From: Simon Davis
Sent: 14 August 2020 15:08
To: Clare Bartlett [REDACTED]
Cc: Daniel Vick <Daniel.Vick@arun.gov.uk>
Subject: RE: AL/49/20/PL Byfields & Nightingale Cottage

From: Simon Davis <Simon.Davis@arun.gov.uk>
Sent: 11 August 2020 14:56
To: Clare Bartlett [REDACTED]
Subject: AL/49/20/PL Byfields & Nightingale Cottage - Design & Highways

Second Floor

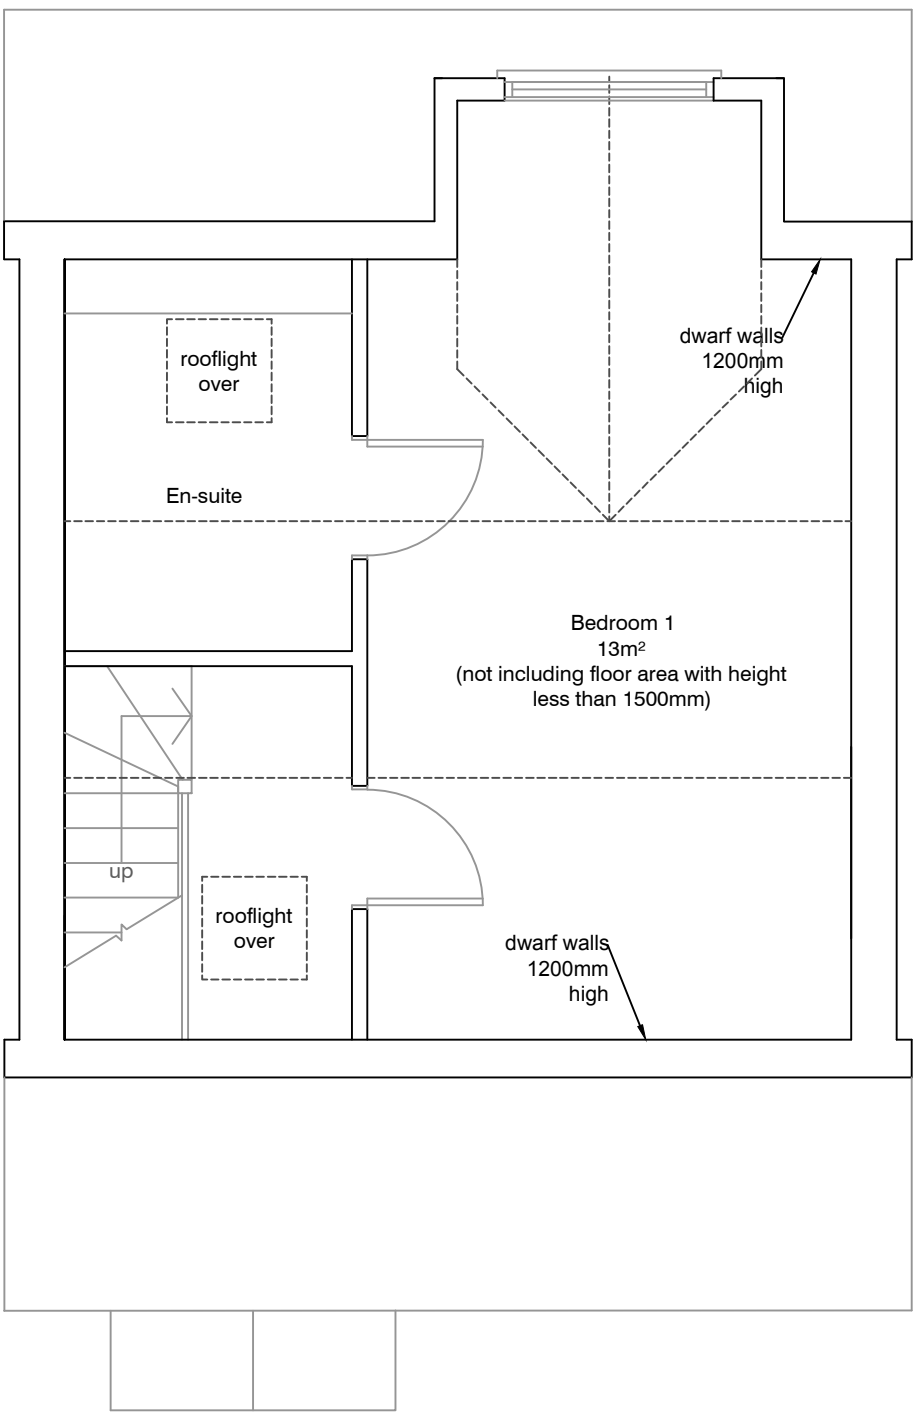
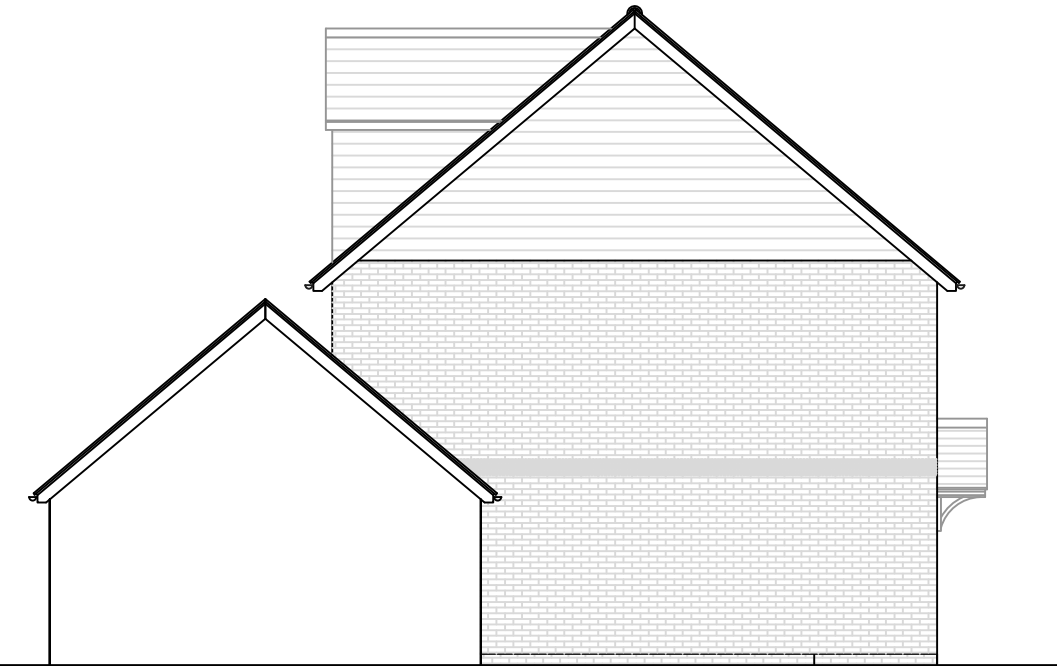
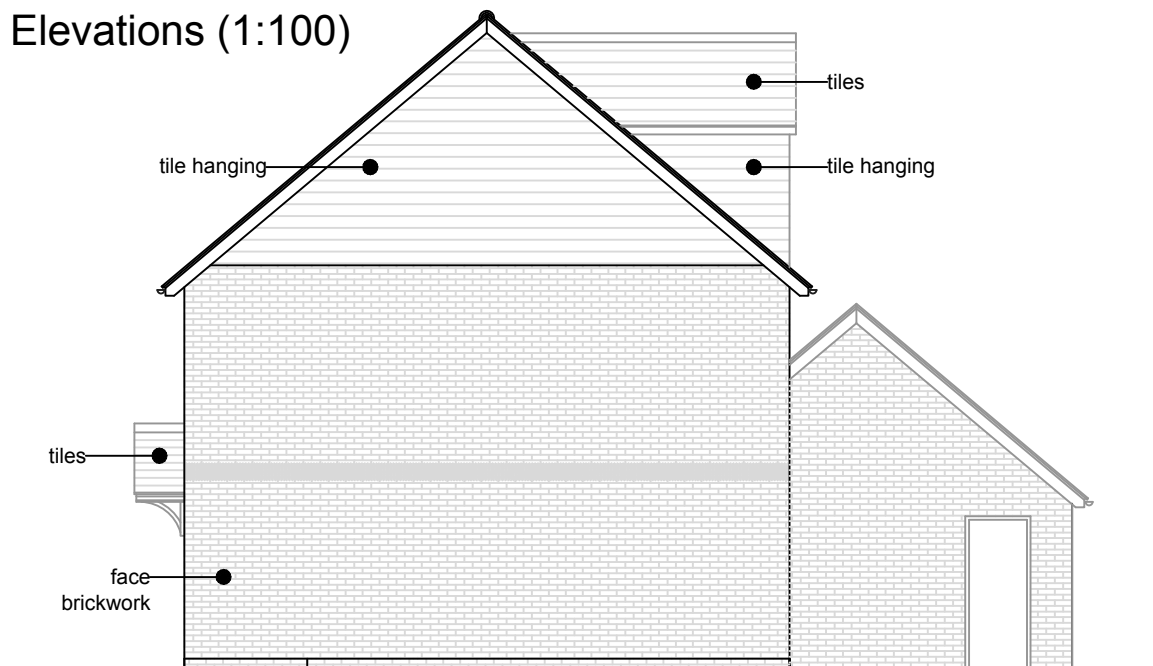
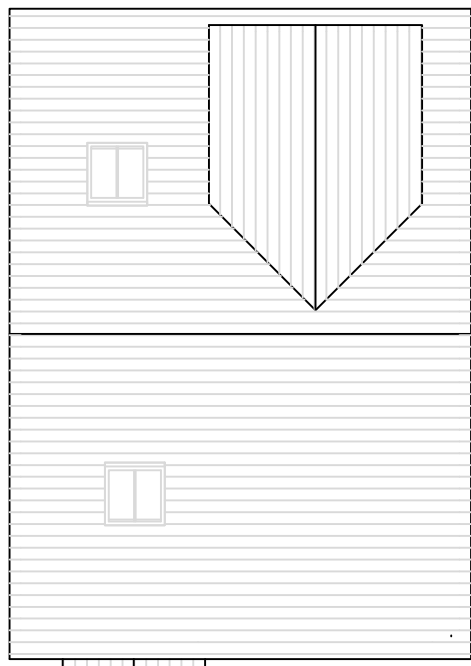
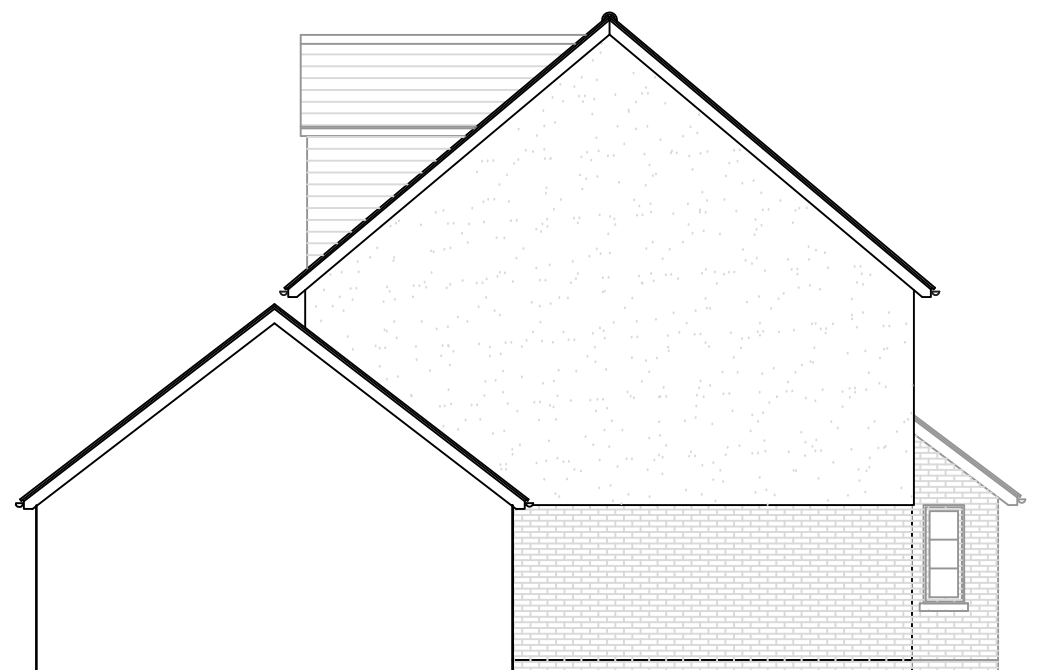
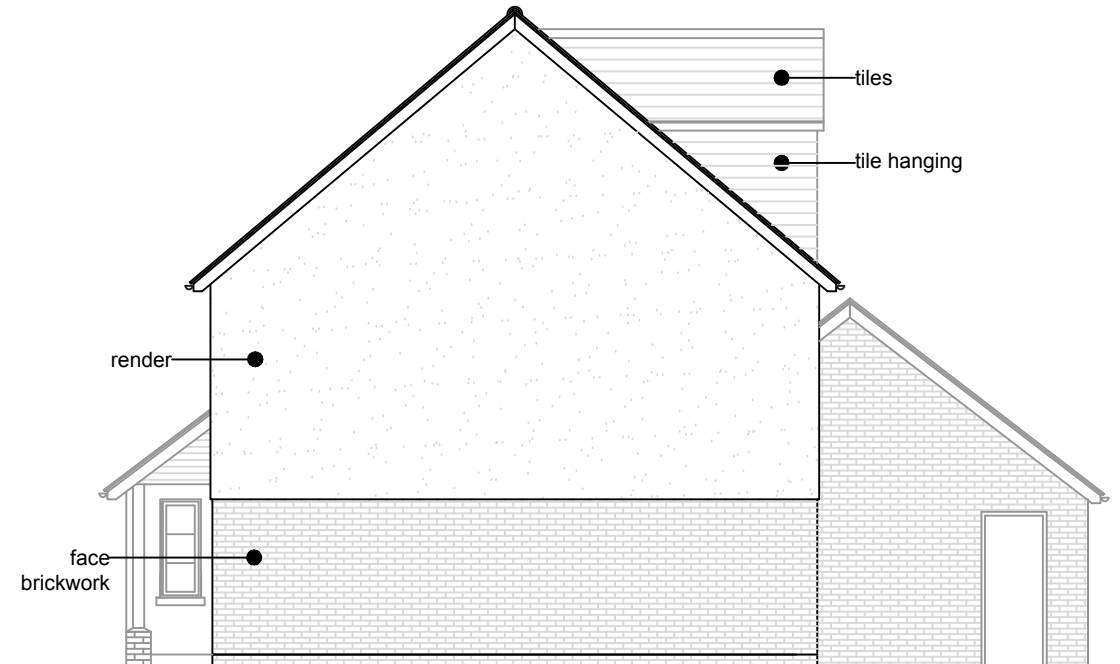
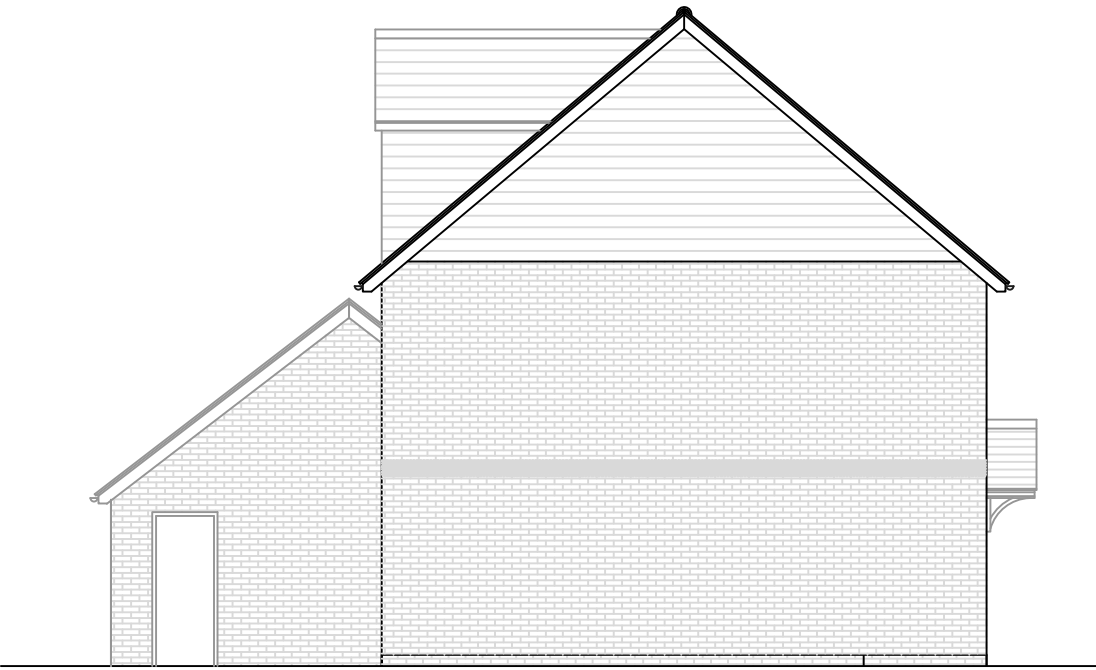
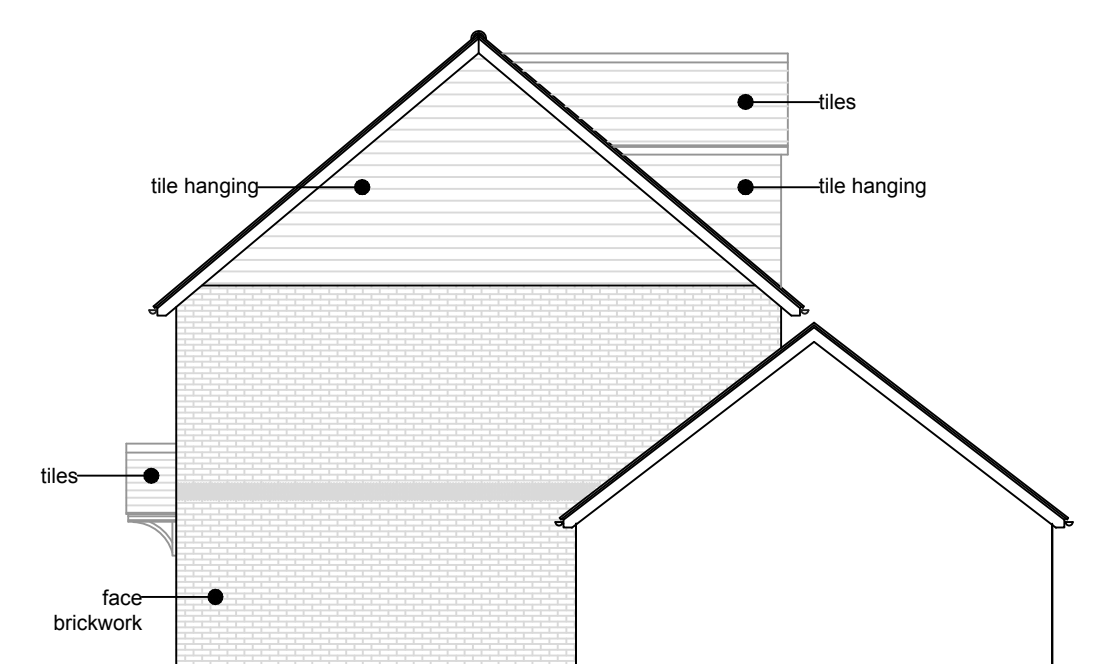
Regarding scale, notwithstanding my comments on the PreApp above, I do note that I stated in that response that whilst an element of 2 storeys would be acceptable, the overriding scale of the new dwellings should be 1.5 storeys. I accept that the dormers are to the rear elevations however the presence of the front velux's still gives a 2.5 storey impression. Also I am not convinced that the presence of what is clearly an attic window in the Old Stores establishes a 2.5 storey character.

- The site is very much of an urban/rural edge character and the proposals do not reflect this character.
- The elements that make up the character of this site – boundary wall, grass verge, landscaping, spacing will all be destroyed as a result of the proposals.
- The design is poor and does not appear to be based on local character/context. Either side of the site are dwellings with a relatively strong character, yet what is proposed is at odds with that.
- Surrounding dwellings are predominantly 1.5 storeys yet these are 2.5.
- The trees on the frontage should be respected & retained.
- There may be a scheme here but definitely not 6 dwellings.

I disagree. Only Mill View has 1.5 storeys and this is the most recent addition to the road. The established character is provided by The Old Stores which has the appearance of a 2.5 storey building, and the cottages which are 2 storeys. The proposed scheme has the appearance of 2 storeys from Nyton Road, with the use of loft space only apparent to the rear and this view is screened by trees. The height of the dwellings is also lower than The Old Stores.
